CHAIN VALLEY COLLIERY – MODIFICATION 1

Response to Submissions

Section 96 Modification to SSD-5465

Prepared for LakeCoal Pty Limited
September 2014

Proposed underground linkage
Chain Valley Colliery – Modification I
Figure 3.1

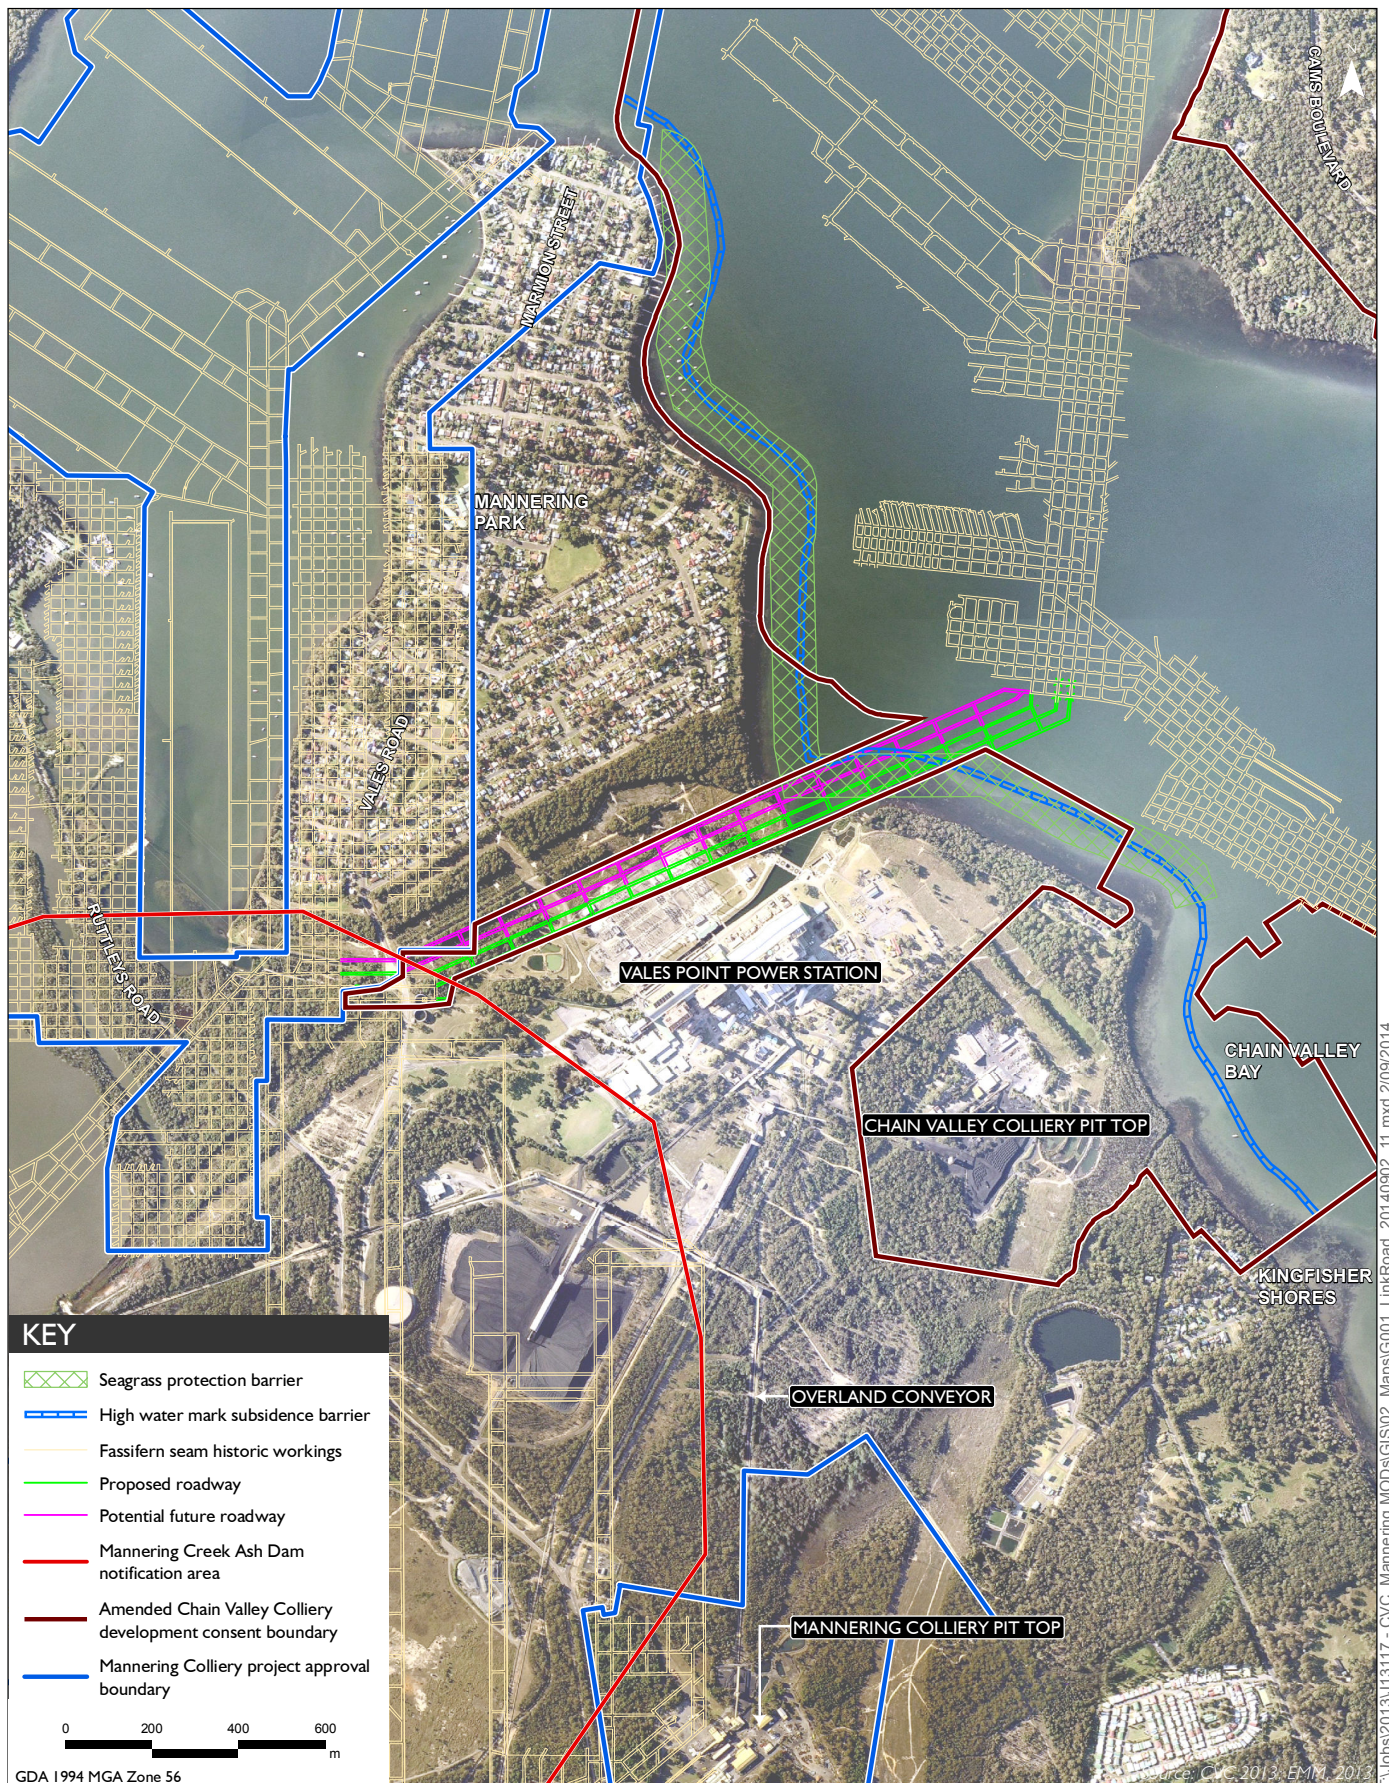
It is important to note that following advice received from the Department of Planning and Environment on 1 July 2014, the proposed amendment to the development consent boundary as described in the EMM (2014) SEE has been revised to extend the full length of the proposed underground linkage to the boundary with the existing MC project approval (MP06_0311) boundary.

The amendment to the CVC development consent boundary is shown in Figure 1, attached as Appendix A.
